Application for approval of matters reserved by condition imposed under AW/211/14/PL relating to conditions 3, 6, 11 & 12 relating to window detailing, watercourse access & maintenance, Servicing Management Plan & pedestrian improvements.

The Ship Inn Aldwick Street Aldwick

Thank you for your internet representation made on 10th March 2015 which has been recorded as '**an objection**' with the comments as follows:

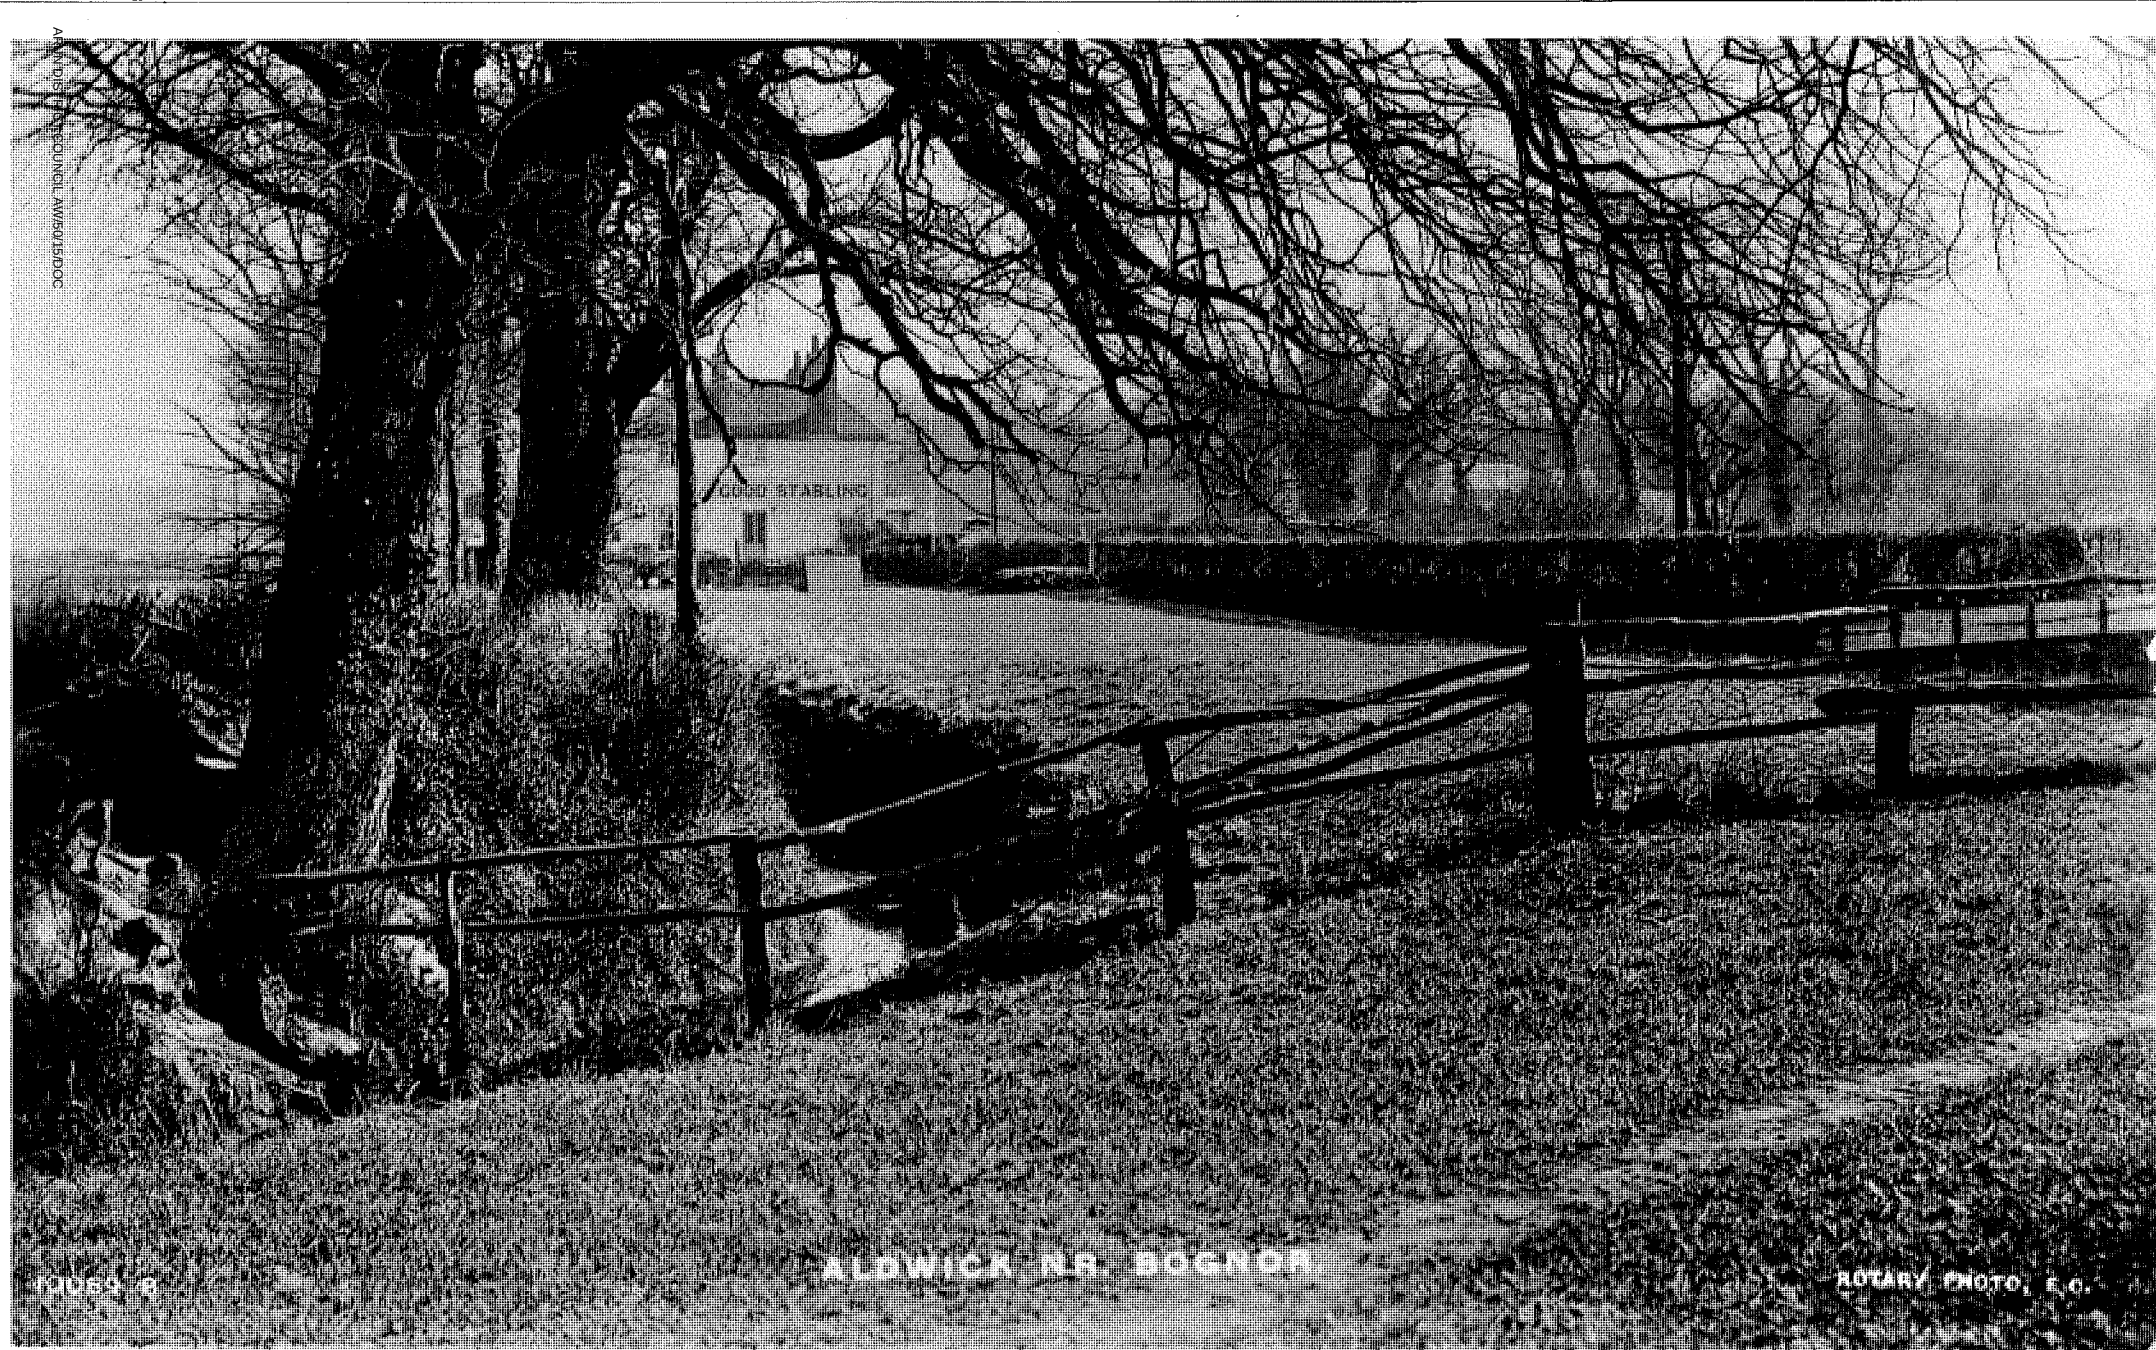
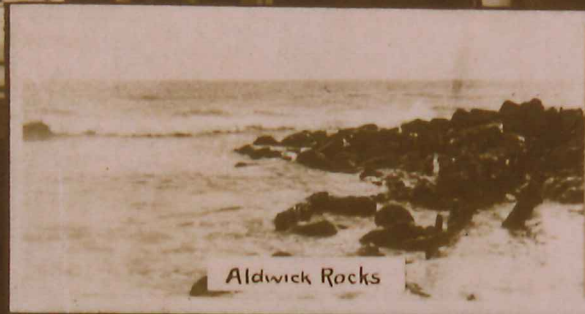
Old Aldwick Picture. Morrisons have stated they are unable to enlarge vintage photographs. This is ridiculous as other companies have managed to do this satisfactorily.

DRAWING TITLE
SWEPT PATH

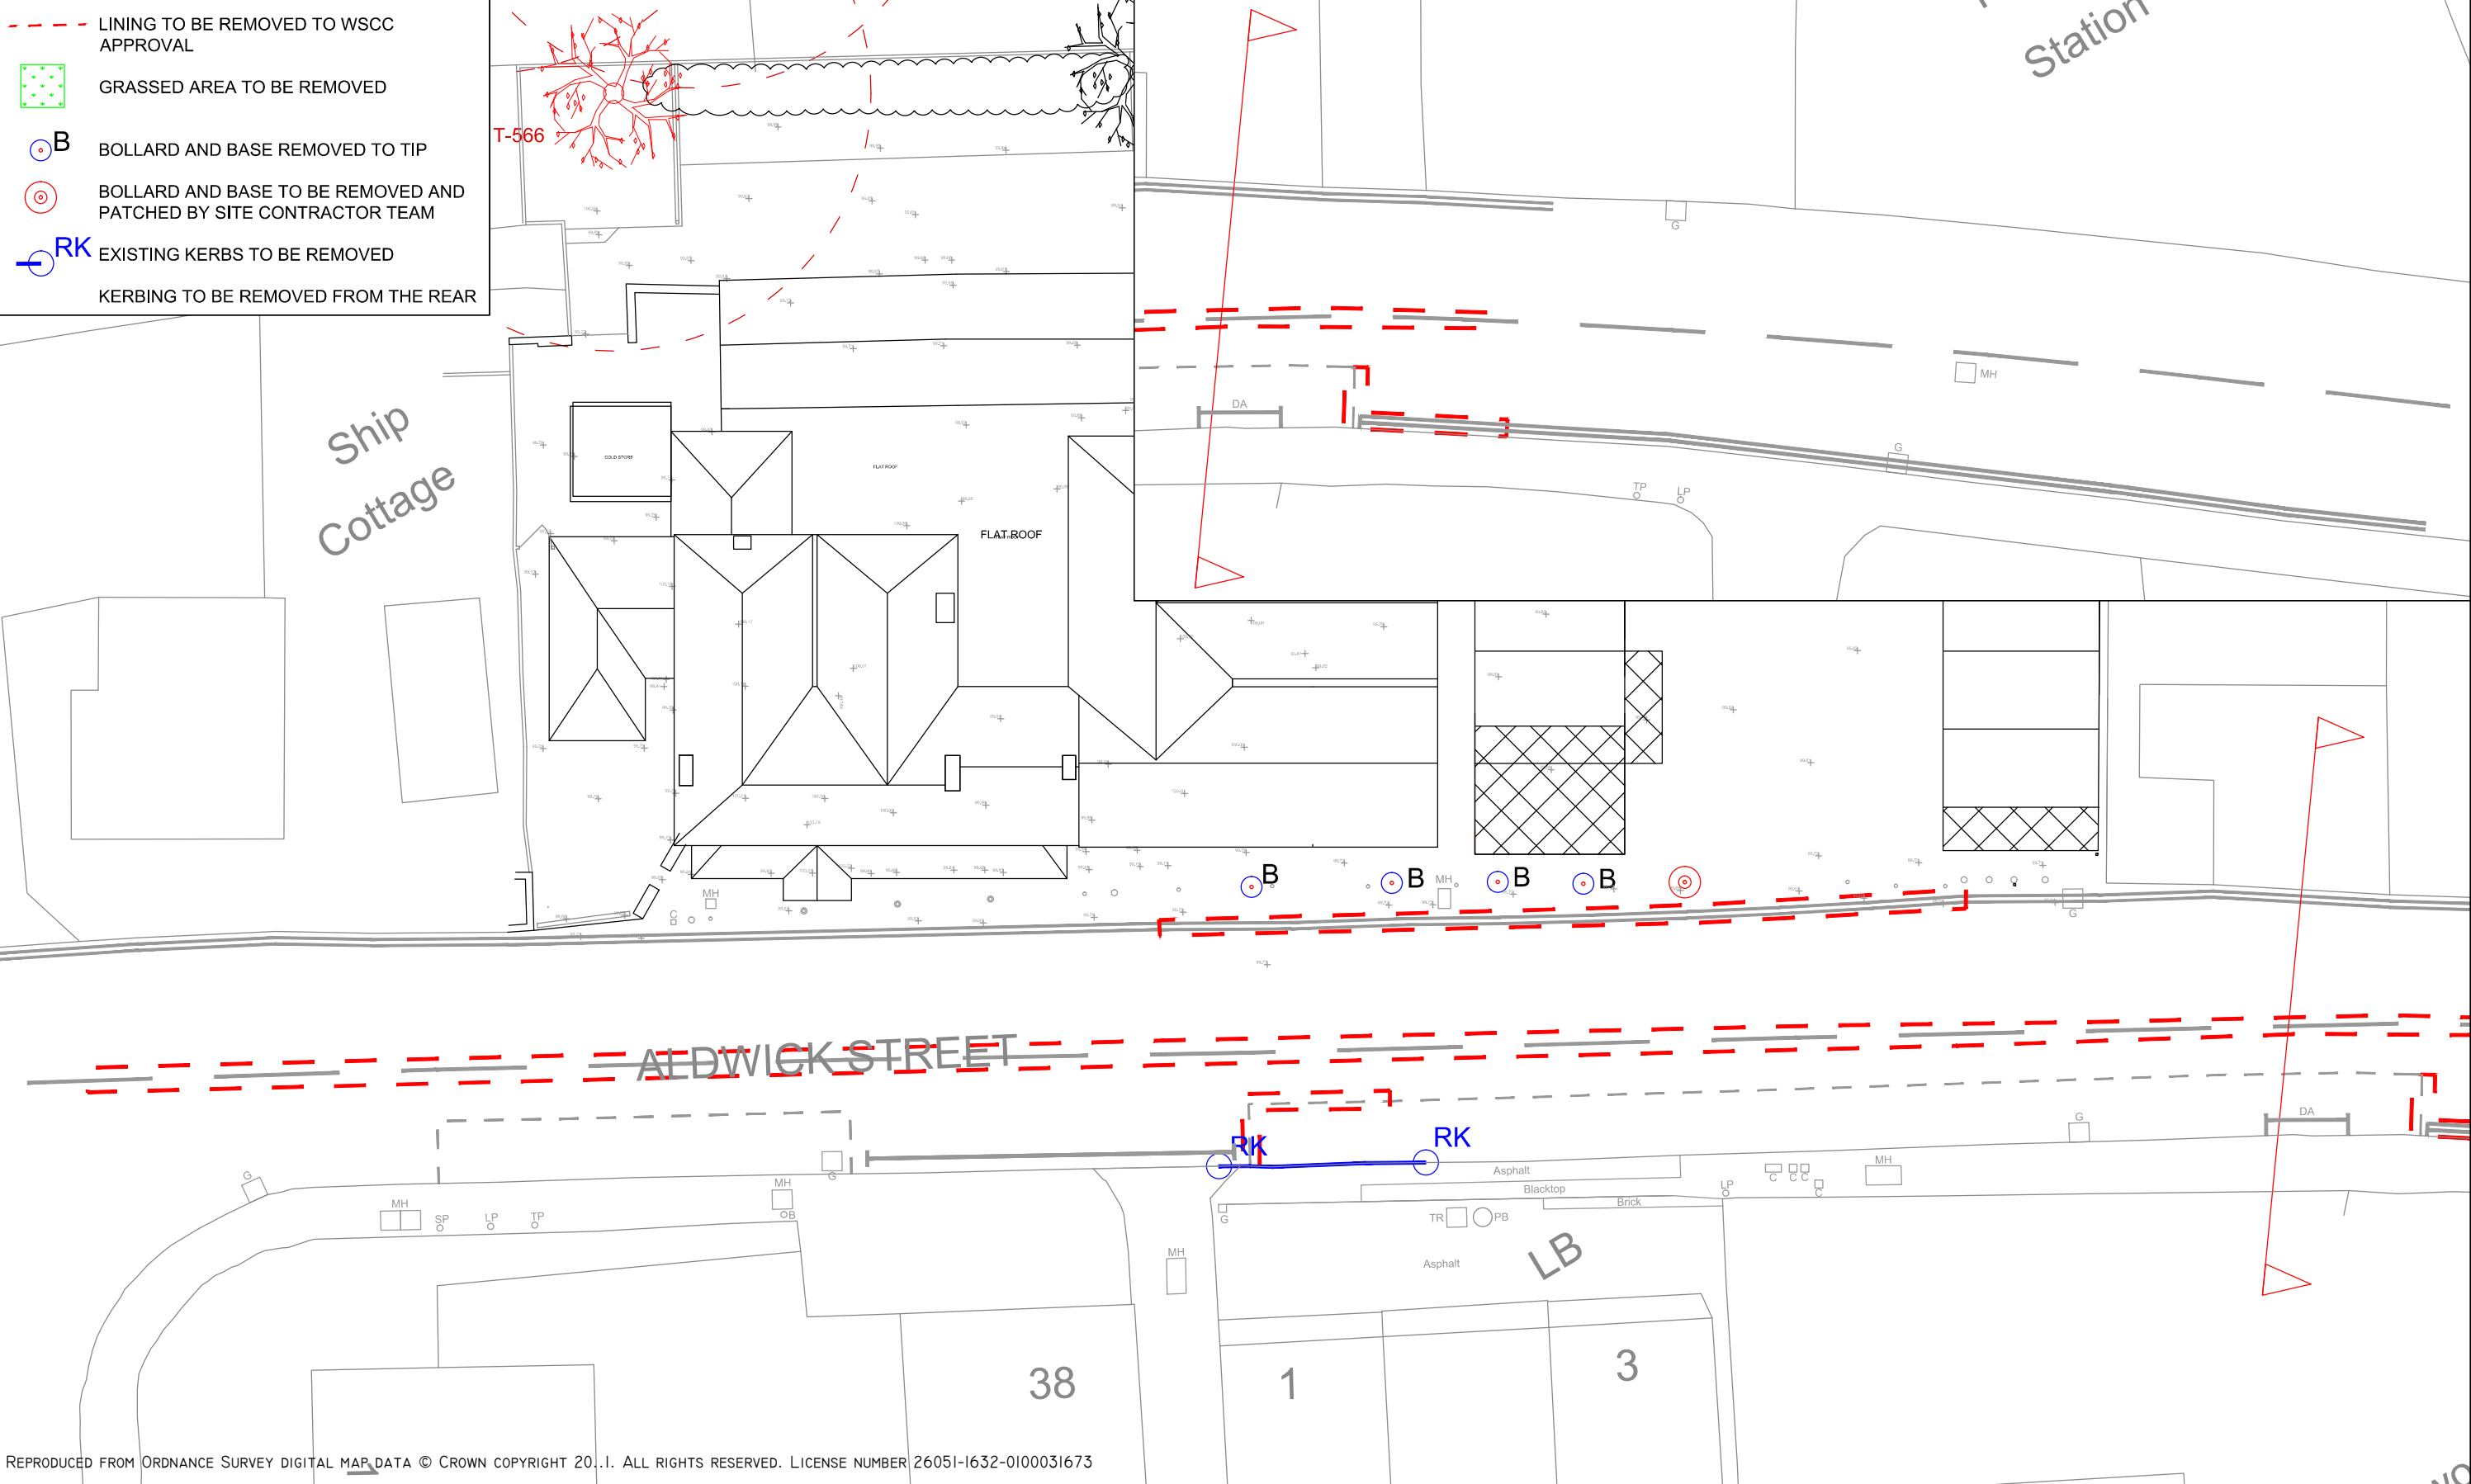
Service Management Plan. Morrisons have submitted a document to manage the car park and twice daily deliveries to it by lorries of more than 30 feet long. There is nothing in the document to instruct drivers how to enter or leave the car park. There is no dedicated member of staff to help the driver to manoeuvre. There is no plan of what to do if the car park is full. Not enough detail in the document.

UNCONTROLLED DROPPED CROSSING:

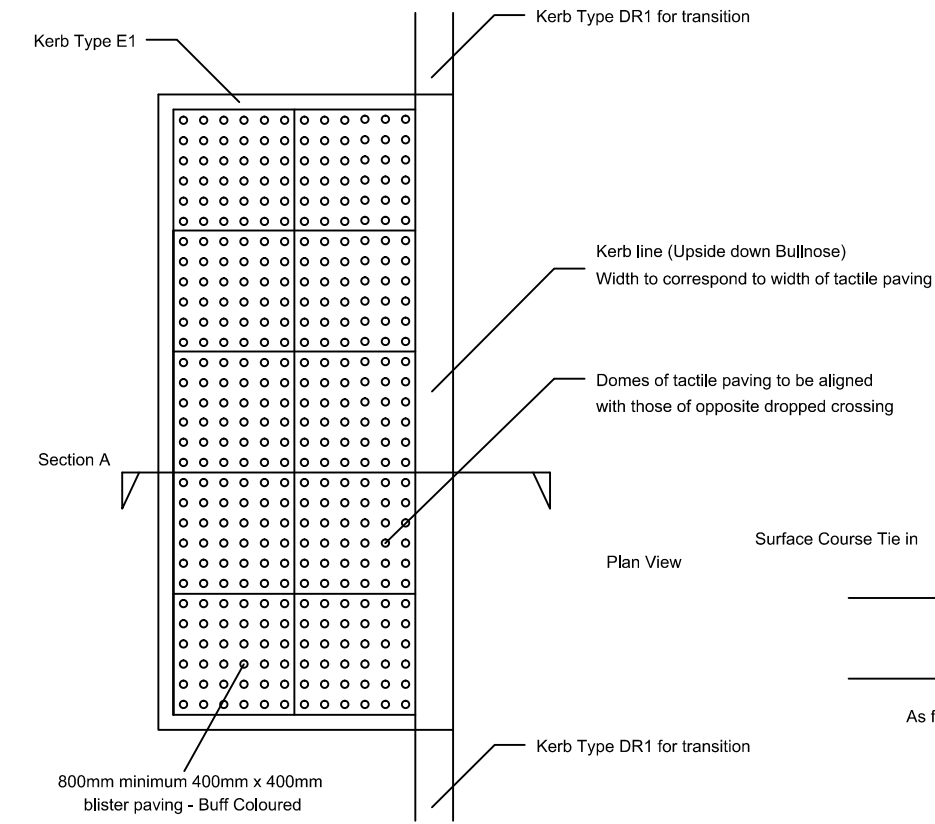
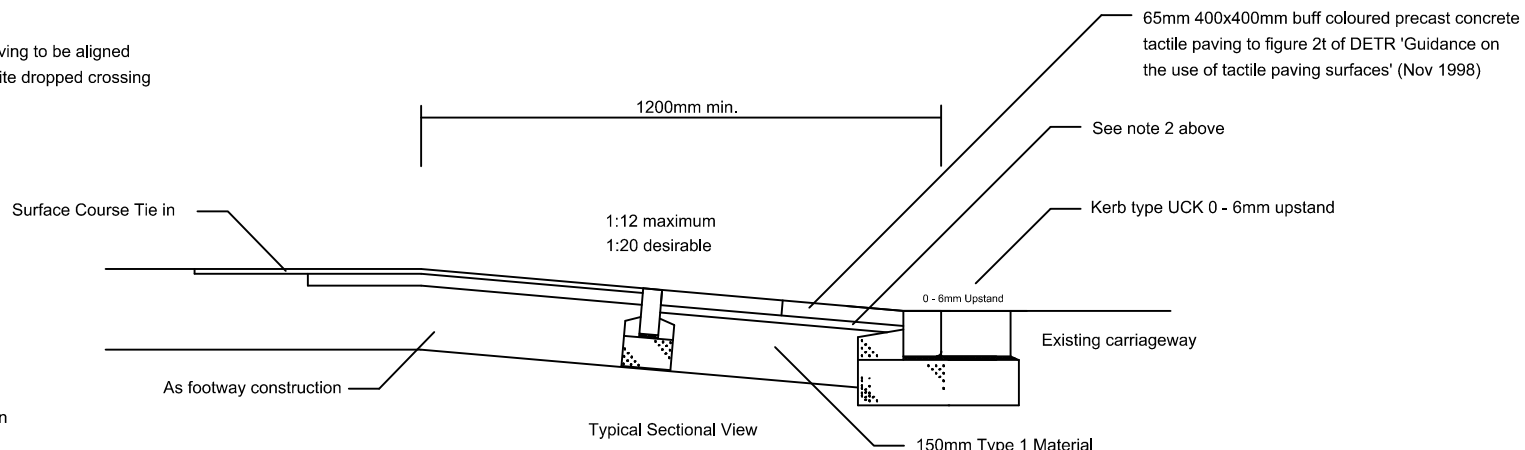
The Uncontrolled Crossing. The crossing should have been installed before the store opened. Further, West Sussex Hifgways state that nothing can be done until there has been a full consultation procedure over moving the car parking bay to accommodate the crossing. That will take a minimum of nine months so there will be no protection for pedestrian shoppers for almost a year, if at all.
